From: Jonathan Best <Jonathan.Best@arun.gov.uk>
Sent: 09 September 2026 10:53
To: Planning.Responses <Planning.Responses@arun.gov.uk>
Cc: Hebe Smith <Hebe.Smith@arun.gov.uk>
Subject: FG/51/26/PL

Ferring Country Centre And Riding Stables Rife Way Ferring BN12 5JZ.

Recommendation: I recommend holding this application until further details are provided on post development BNG and trees.

PROJECT: FERRING COUNTRY CENTRE, WORTHING		SHEET: 1 of 1
TITLE: EXISTING BNG		ISSUE DATE: 03-AUG-2026
SCALE: 1:50 @A3

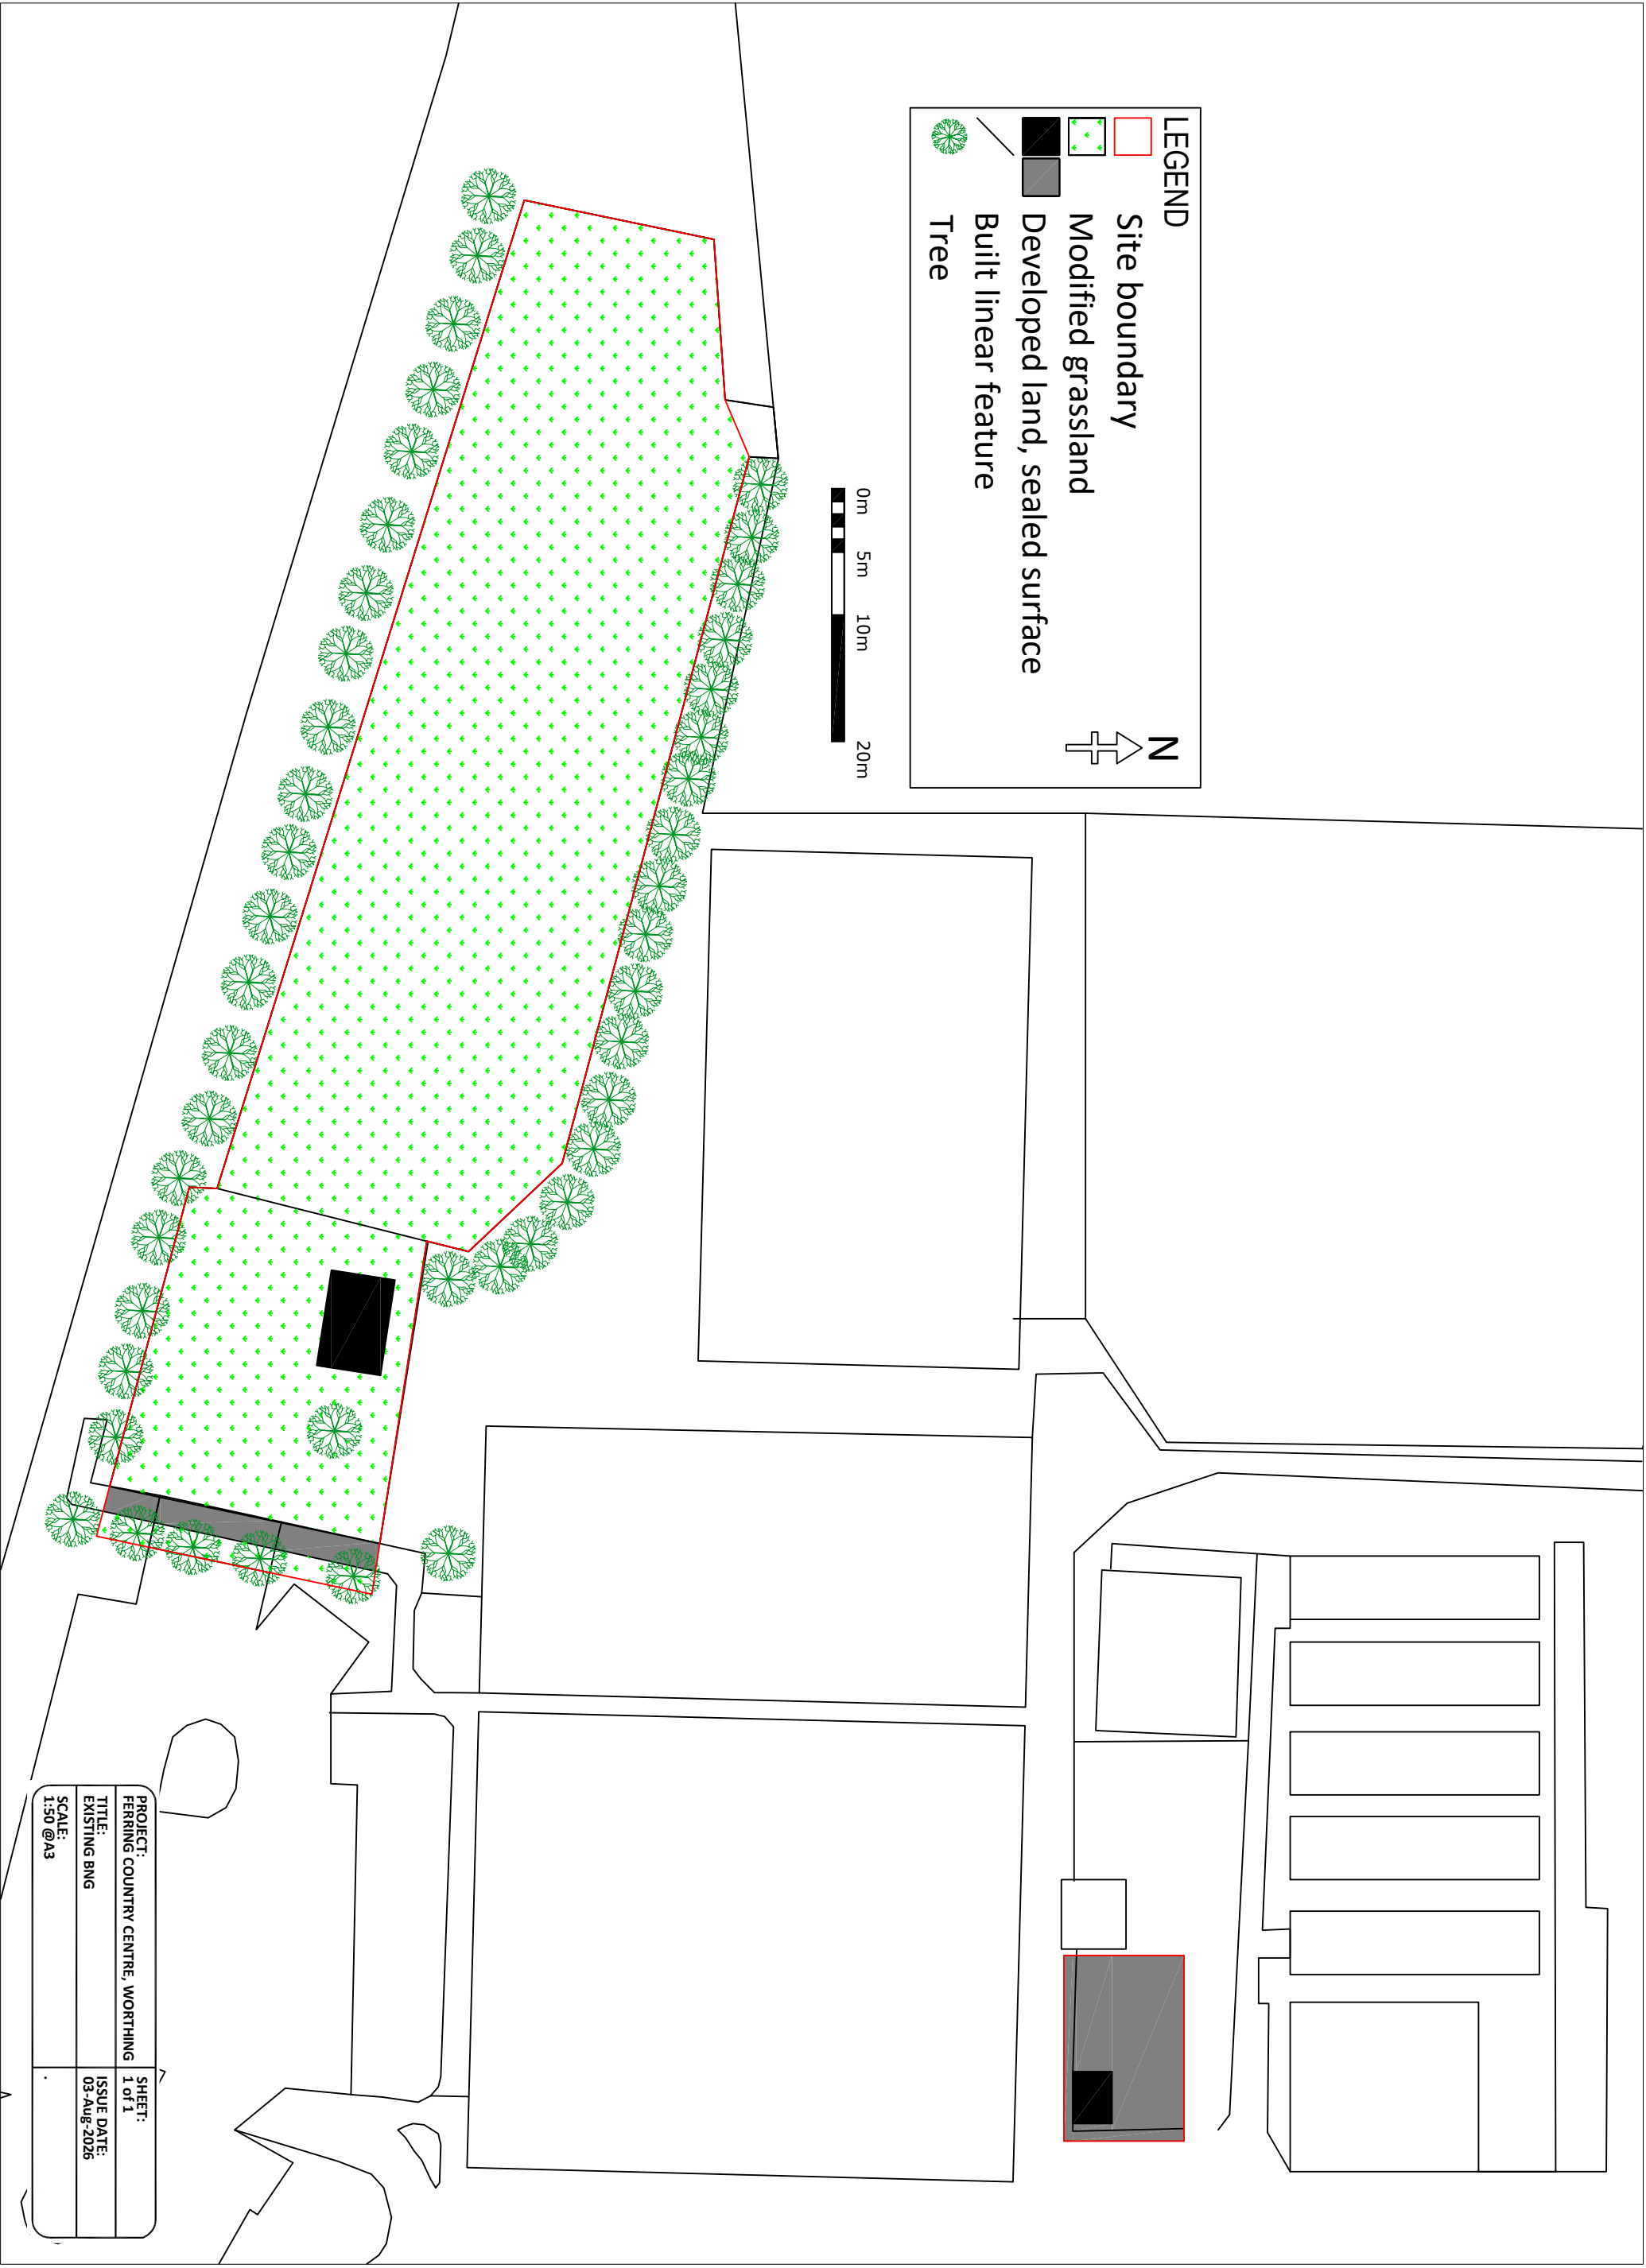
The BNG is delivered through the proposed creation of 0.04ha mixed scrub and 0.2ha of individual trees. However, the site is surrounded by a ring of mature trees. The creation of mixed scrub is high risk and considered unfeasible because no tree assessment has been undertaken and the root protection zones have not been identified so planting in the root zones could damage the tree roots and limit the successful establishment of the mixed scrub due to shading and competition for water and nutrients.

It would be advisable to locate the BNG enhancements on another part of the site where trees are not a constraint.

I advise an arboricultural assessment is provided.
